**RESPONSE TO THE DEPARTMENT'S RESPONSE TO SUBMISSIONS
ELIZABETH DRIVE SUBDIVISION (SSD 8859)**

Ae Design Partnership has prepared this letter on behalf of Elizabeth Drive Pty Ltd ("**the Applicant**") in response to the Department's Request for Response to Submissions letter dated 15 April 2019 (**Attachment 1**) in relation to the State Significant Development 8859 ("**SSD 8859**") application on the property legally identified as Lot 2 Section 4 DP 2954, otherwise known as No. 1111-1116 Elizabeth Drive, Cecil Park ("**the site**")

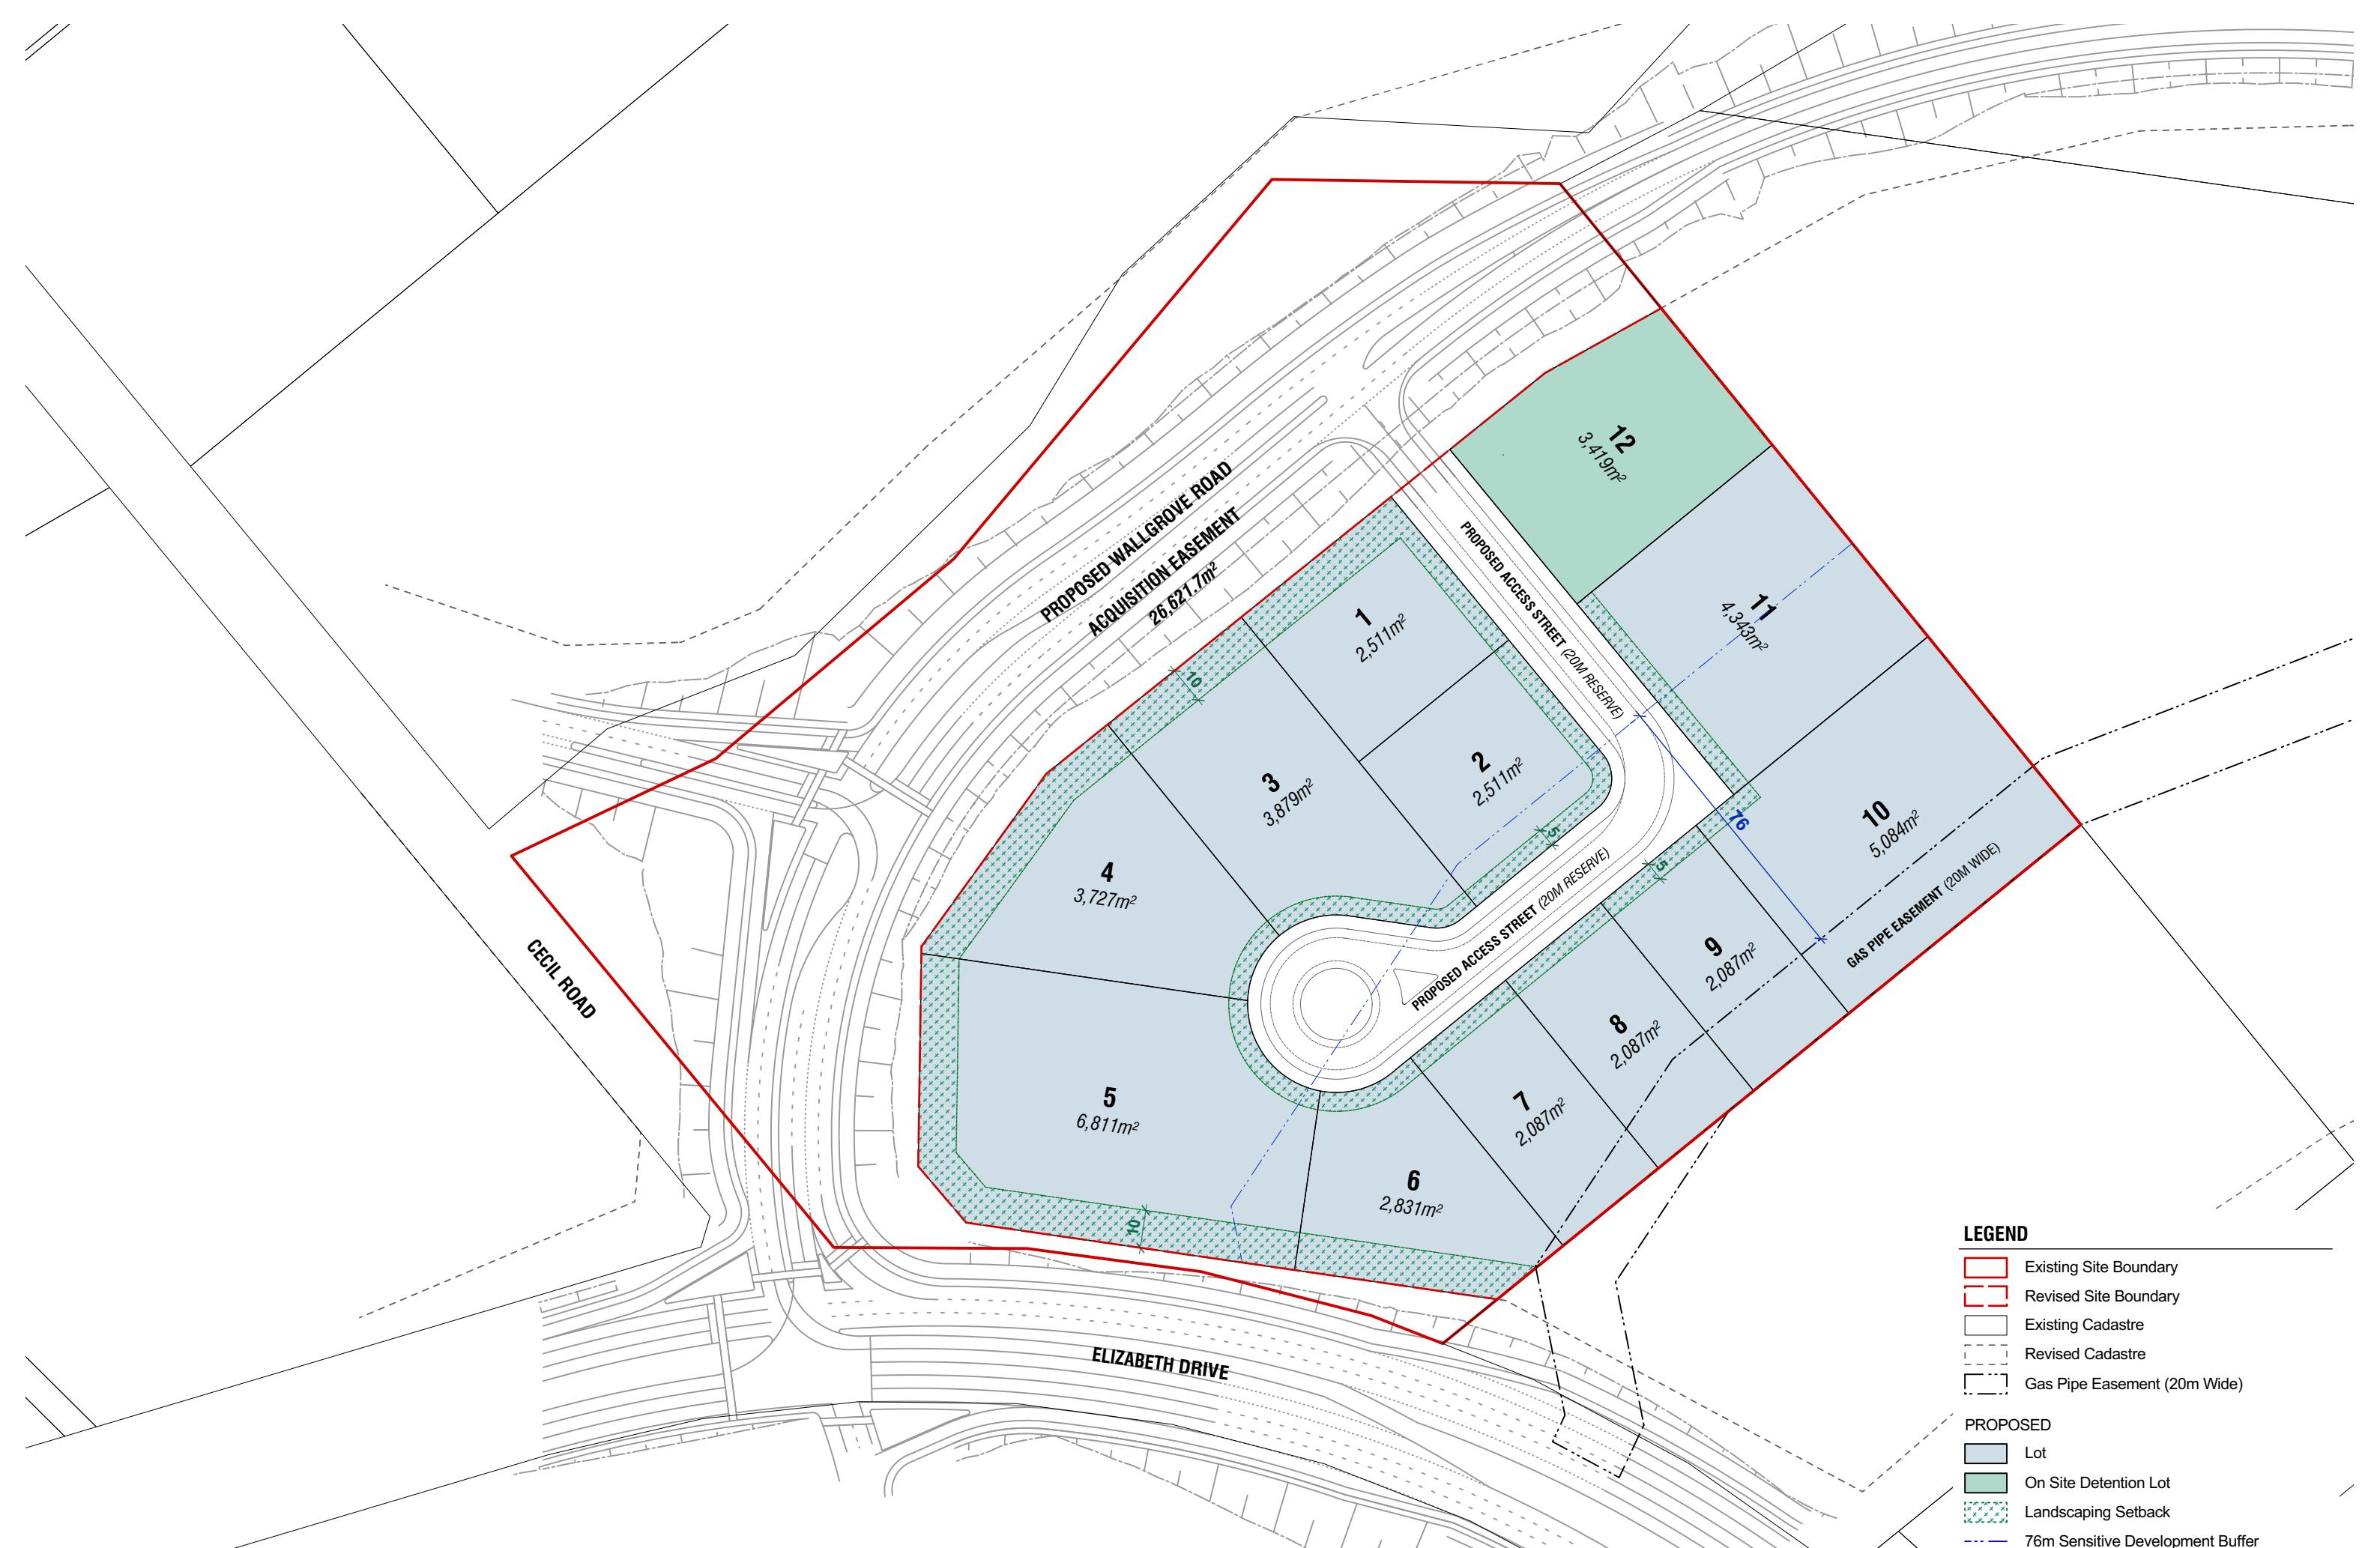
23.	Provide a detailed landscape plan specifying the location of proposed plant species, setbacks and the total area in square meters proposed to be landscaped across the business hub.	A Detailed Landscape Plan has been provided at Drawing Sheet DA08 in the Drawing Package at Attachment C .
Geotechnical Engineering

EARTHWORKS GRADING PLAN		DATA	
DRAWN	CHECKED	DATE	ISSUE
SB	RD	14/08/2020	AI

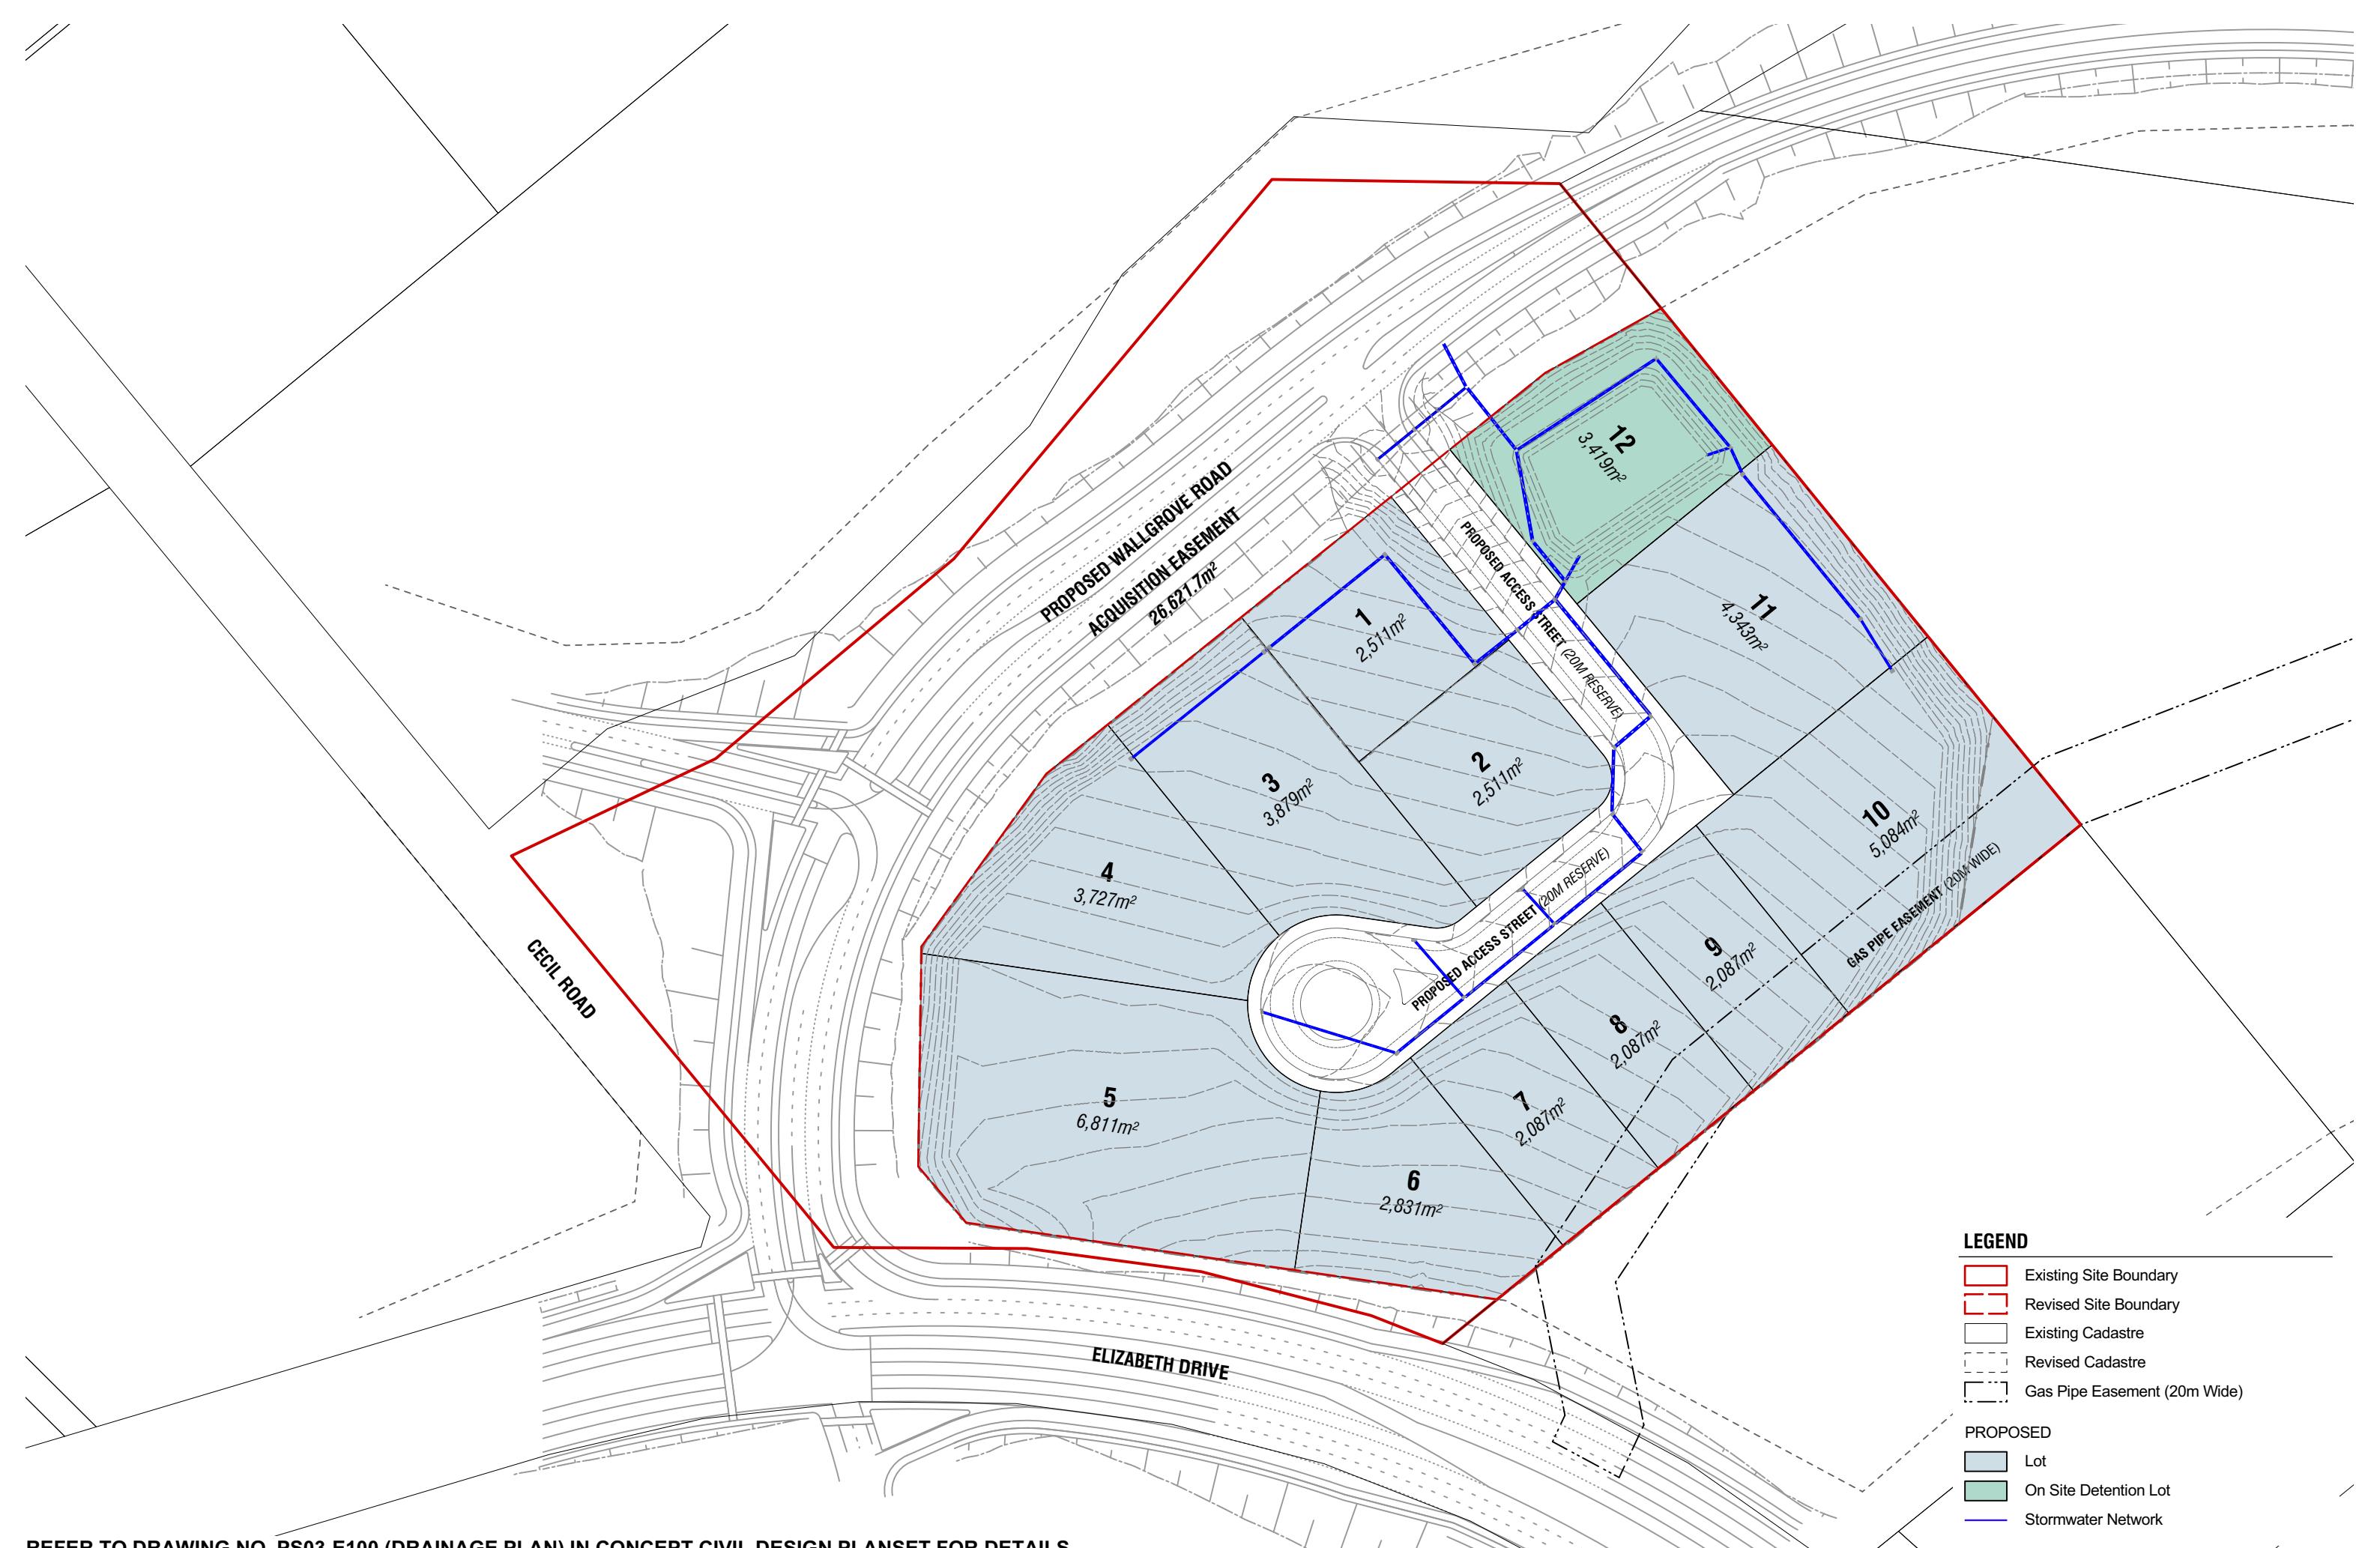
24.	Provide a detailed retaining wall plan which shows: a. Height of all proposed retaining walls	Details of proposed retaining walls is provided on the Earthworks Grading Plan on Drawing Sheet PS03-C100 in Attachment G .
